Application number: 2026/92450	
What is the application for?:	Demolition of existing workshop and erection of detached dwelling
Address of the site or building:	Workshop between, 12 & 14/16, Temple Street, Lindley, Huddersfield, HD3 3JG
Postcode:	HD4 6HF

Type of comment: An objection	
Do you wish your comments to be published on the website anonymously?	Yes

Revision	Description	Issued	Checked	Date
Client: Mr & Mrs McGowan				
Project: The Workshop, Temple Street, Lindley.				
Drawing: Scheme As Proposed				
Drawing Status: PLANNING				
Date: FEB 26	Scale @ A1: 1:100	Drawn by: AB		
Project No: 298	Drawing No: (0-) 02	Revision:

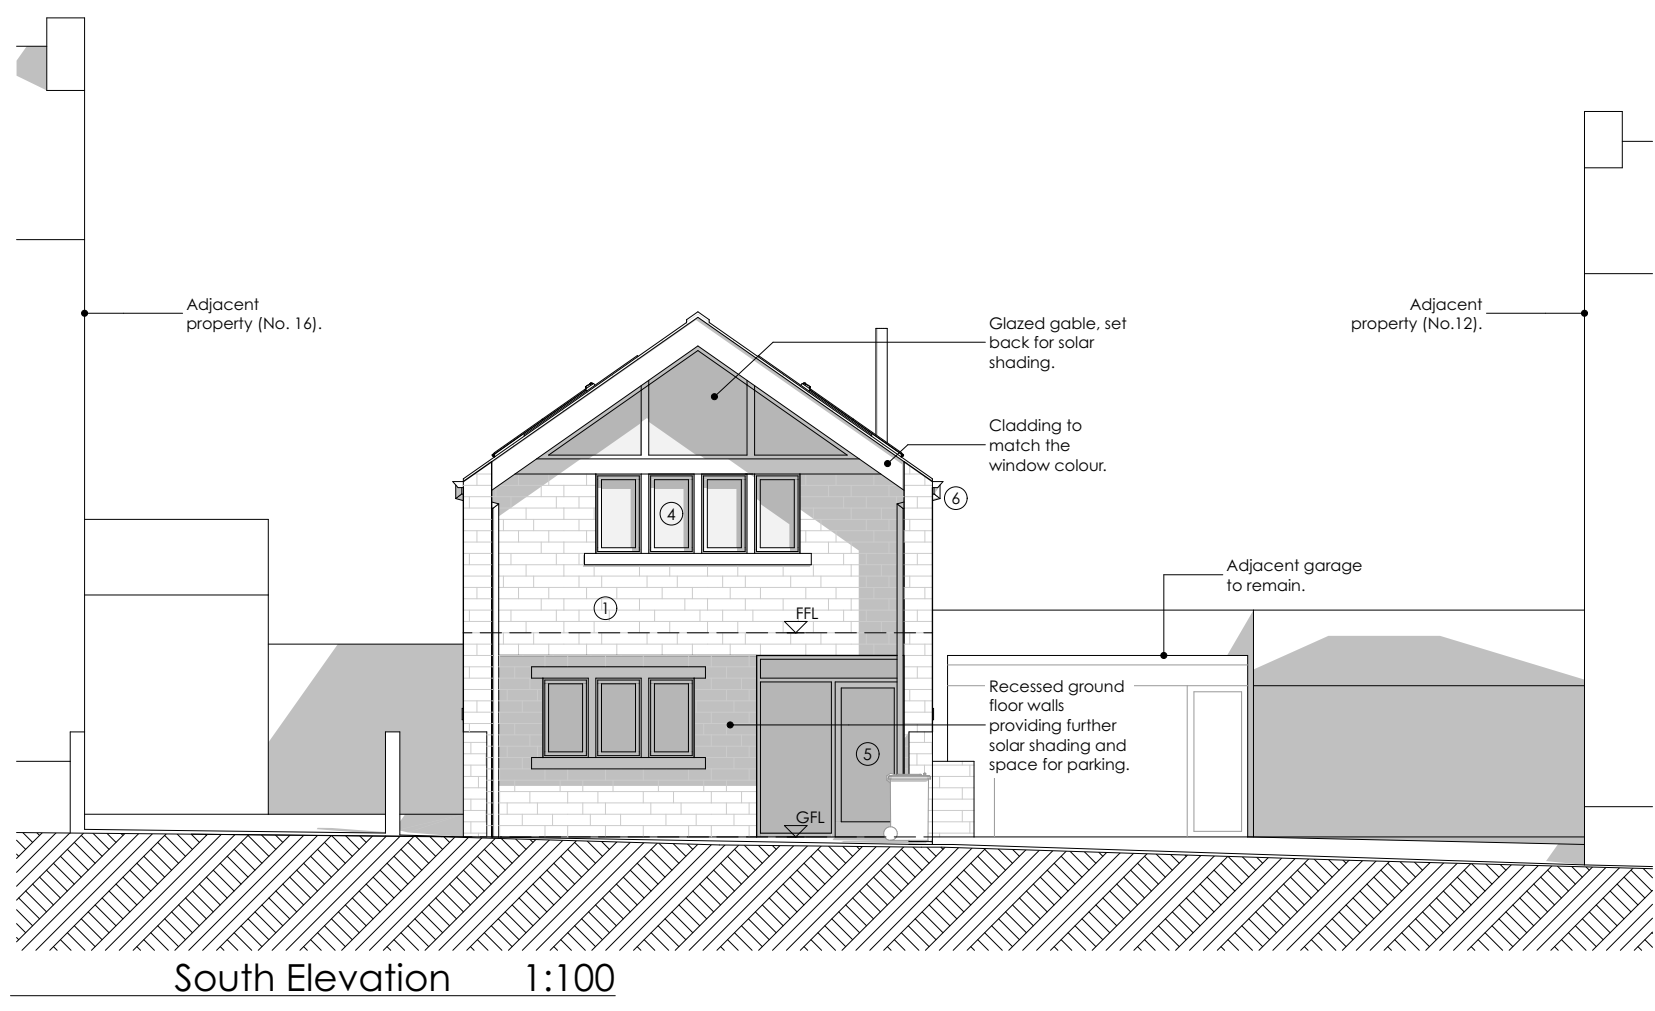
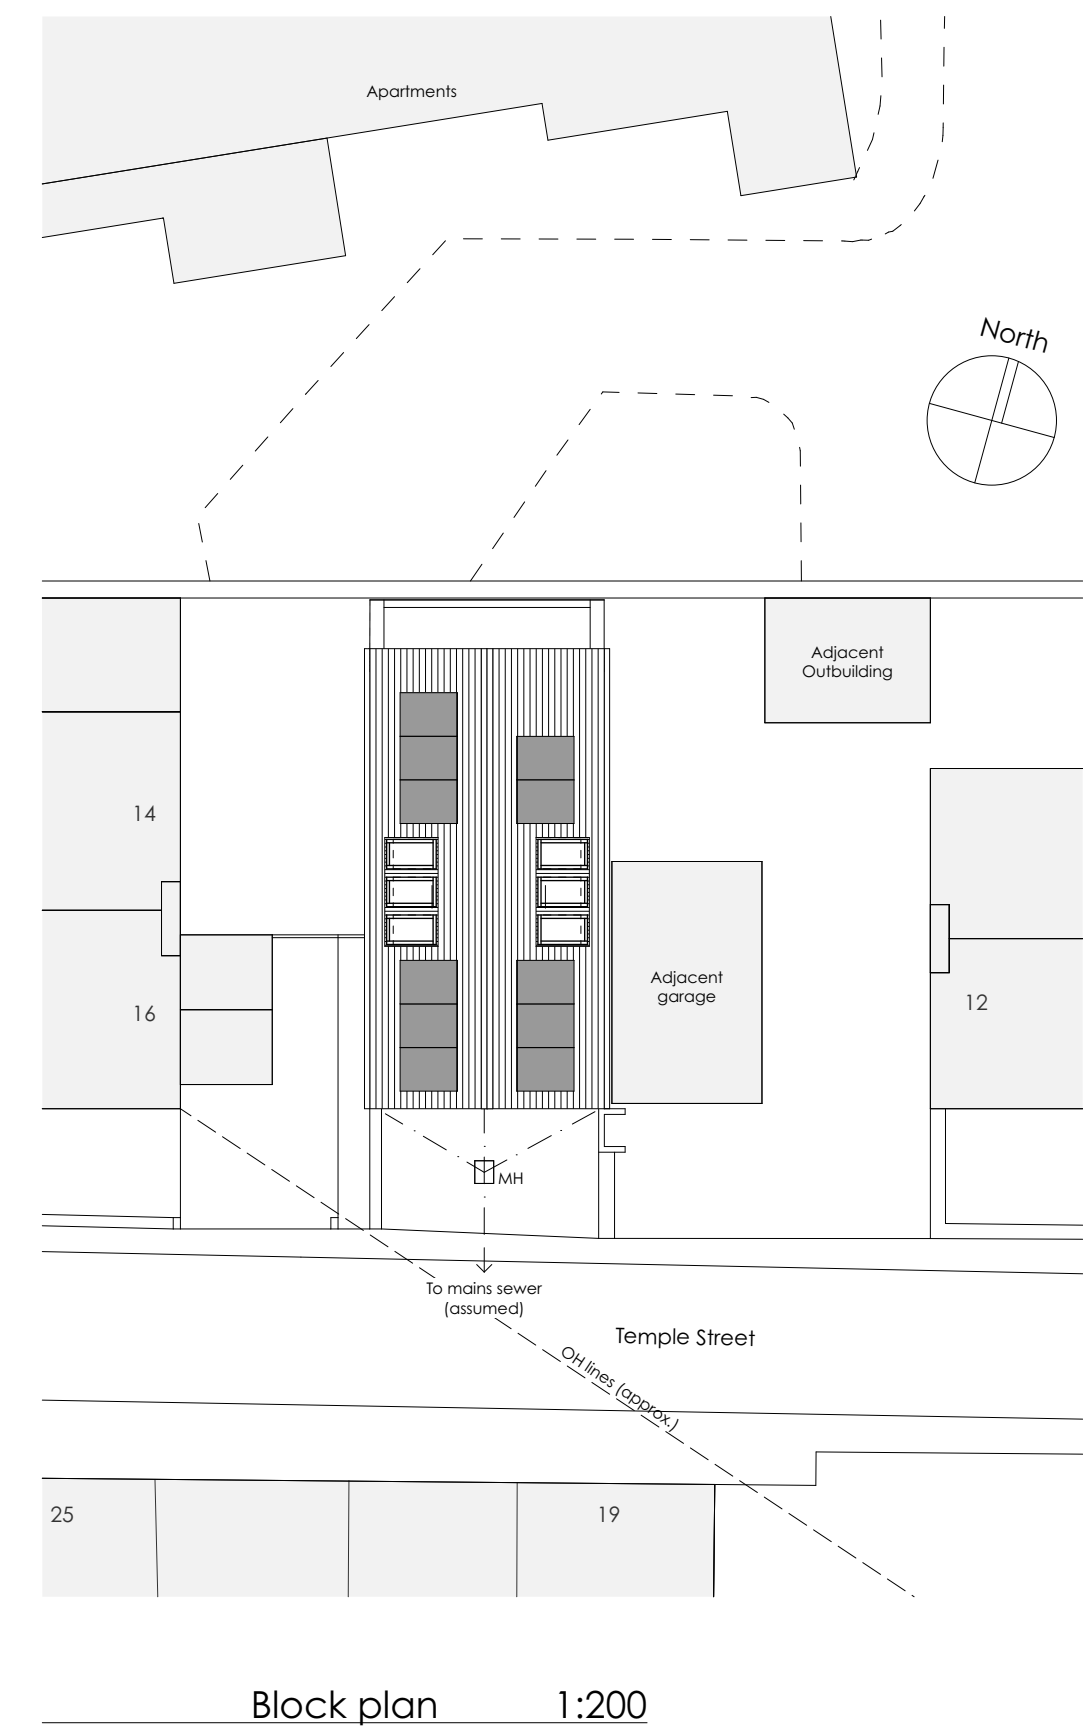
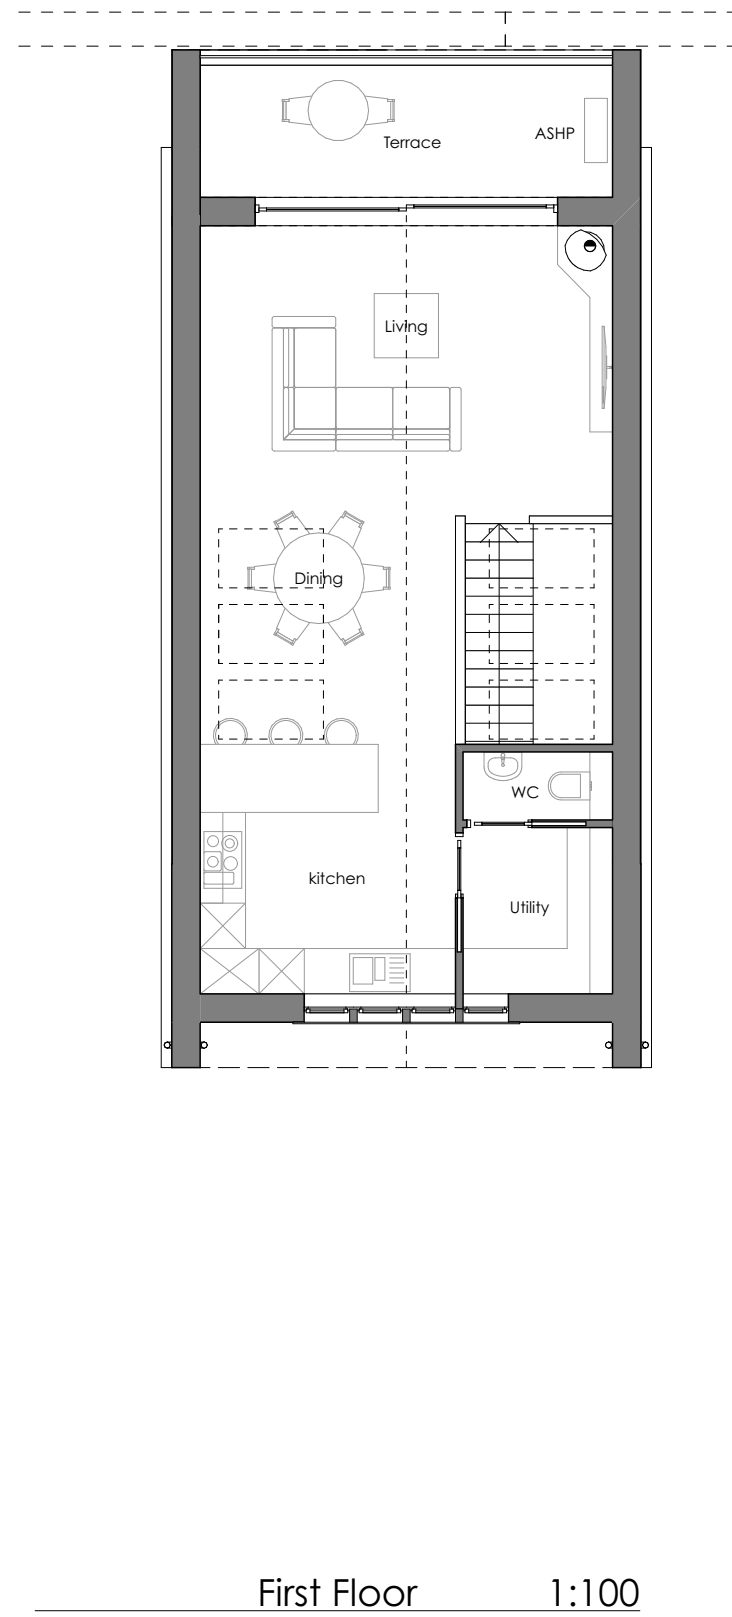
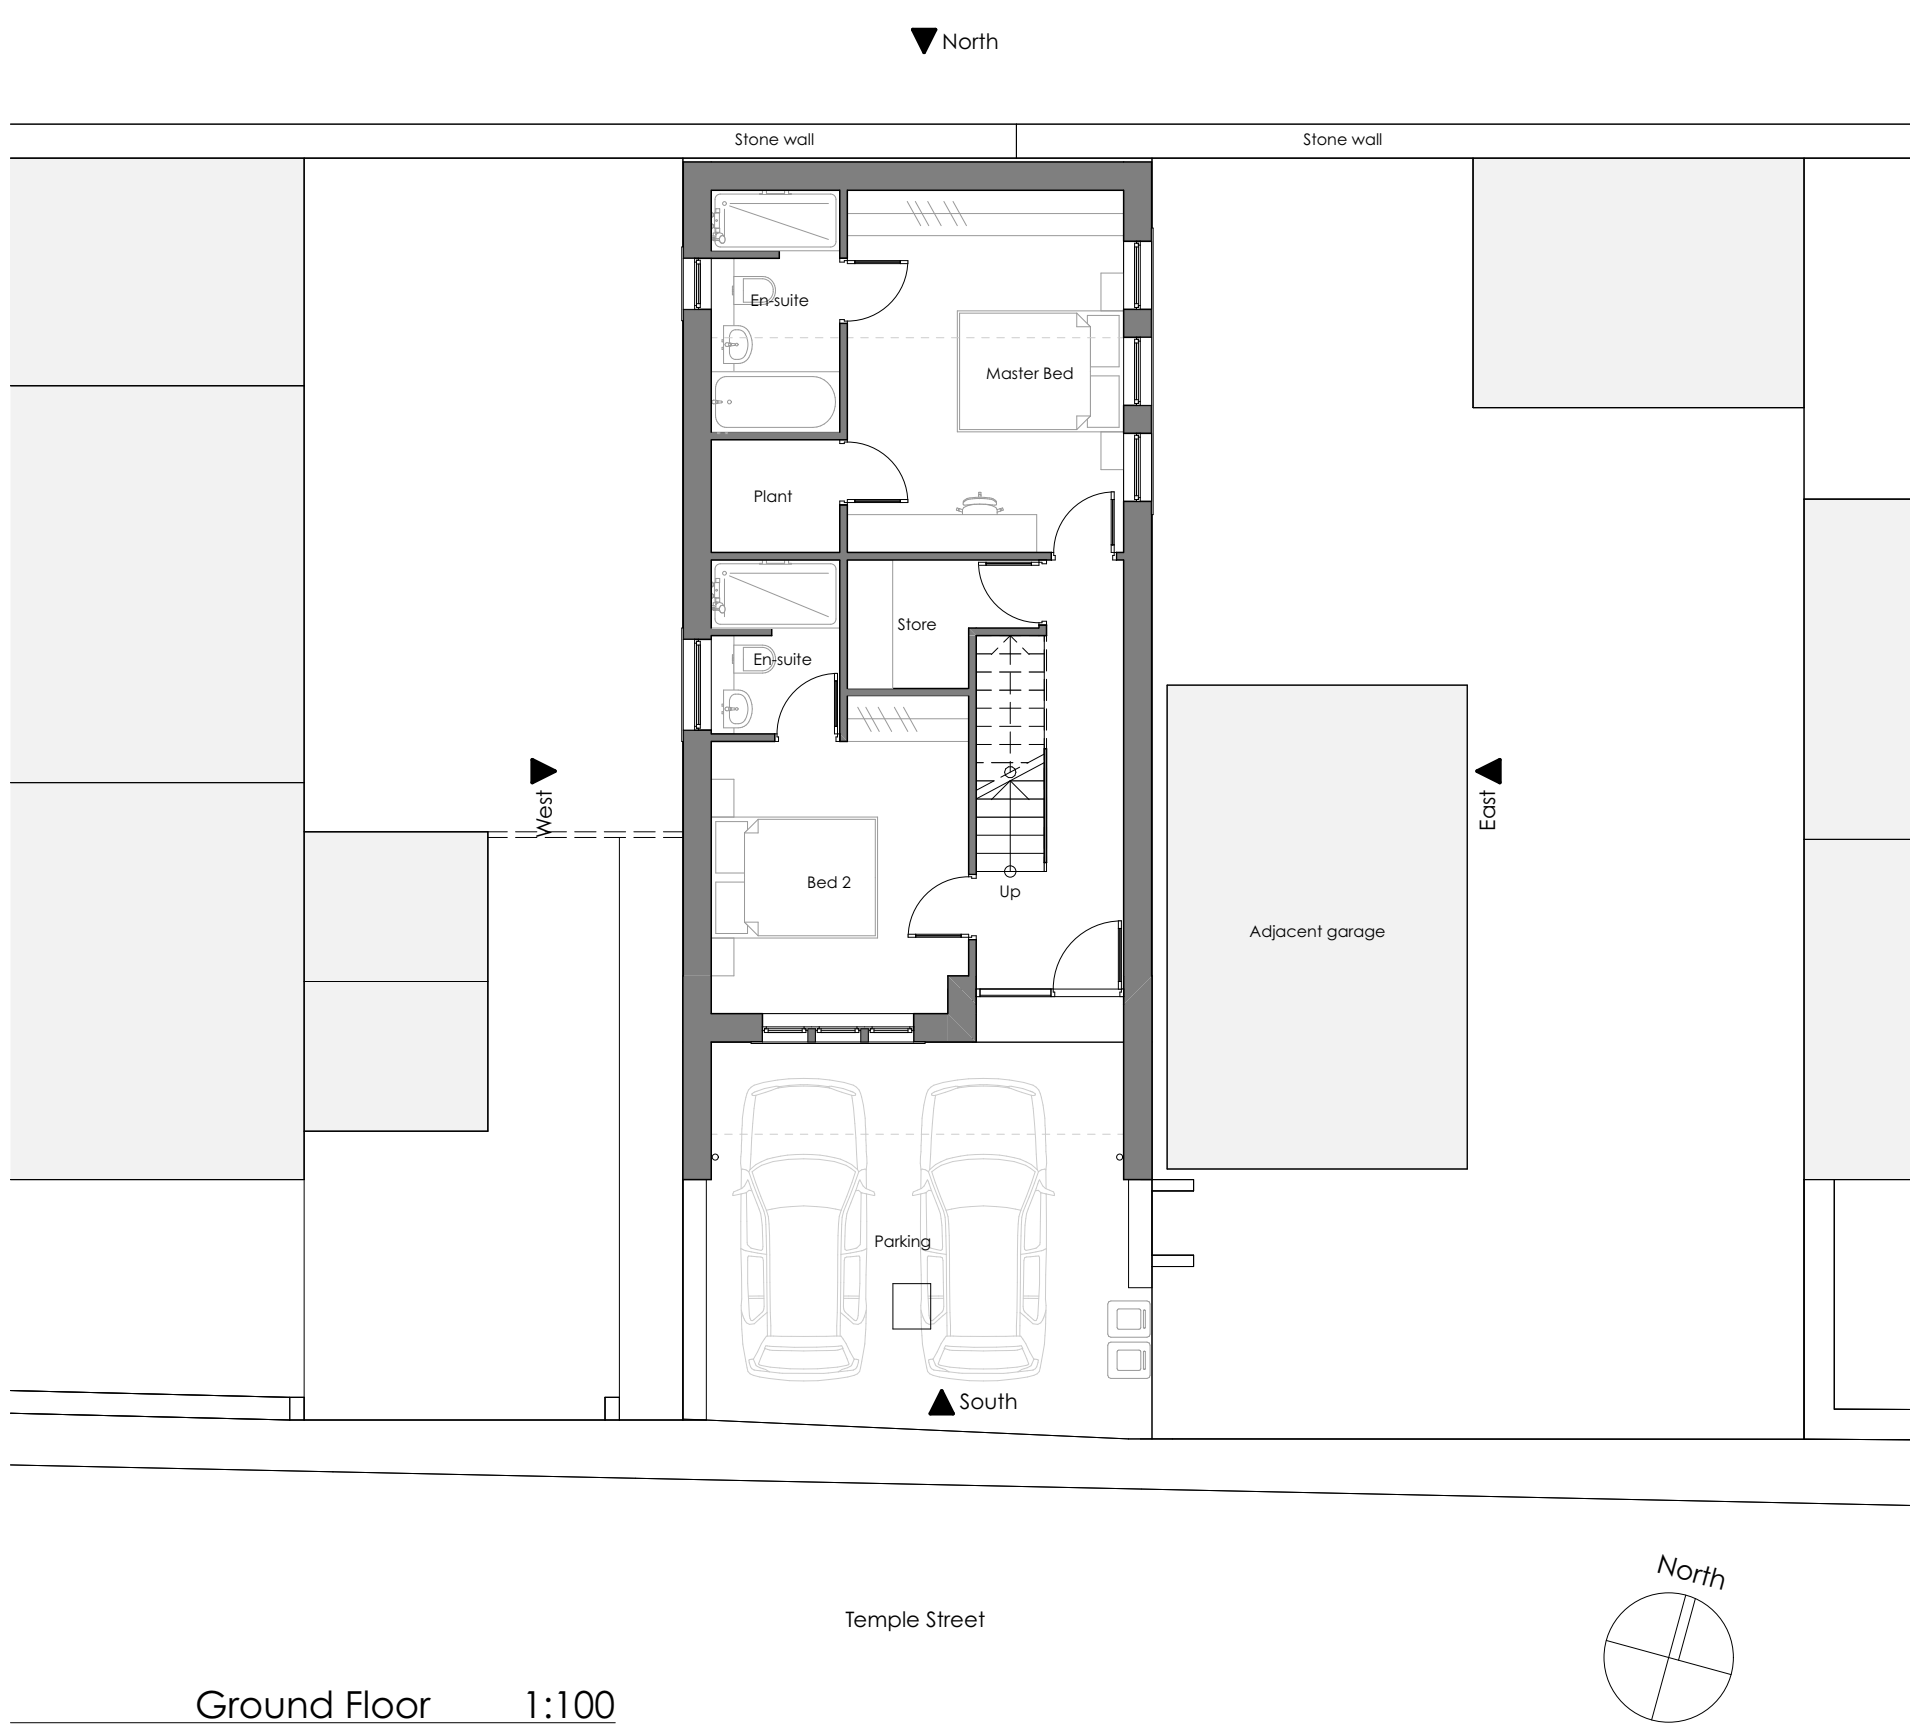
I strongly object to the inclusion of a ground-floor bedroom windows positioned . While I note the window is intended to be frosted glass with a 1.7m FFL inward-opening top vent, the fact that this window serves a primary habitable room (a bedroom) violates standard planning policies regarding residential amenity and design layout. I request that the planning department refuses permission or enforces a mandatory redesign of the building layout based on the following material planning considerations:
Loss of Privacy and Unacceptable Impact on Residential Amenity

Noise, Nuisance, and Loss of Quiet Enjoyment via
the Opening Vent

This layout creates an unacceptable reciprocal noise nuisance that cannot be mitigated by obscure glass. Conflicts between Ventilation Requirements (Part F) and Fire Safety (Part B)

this design creates an irreconcilable conflict with UK Building Regulations: Under Building Regulations Part B (Fire Safety), an opening window or "unprotected area" directly presents an unacceptable risk of fire spread and is strictly limited or prohibited. To comply, windows typically must be non-opening and fire-rated. However, under Building Regulations Part F (Ventilation), a bedroom requires an openable window area or adequate purge ventilation. Because the window cannot be safely conditioned to be fixed shut without depriving the habitable room of required ventilation, the current design is fundamentally unworkable. The window must be entirely omitted from this boundary elevation and the room redesigned with an alternative layout or outlook.
Conclusion & Requested Action.
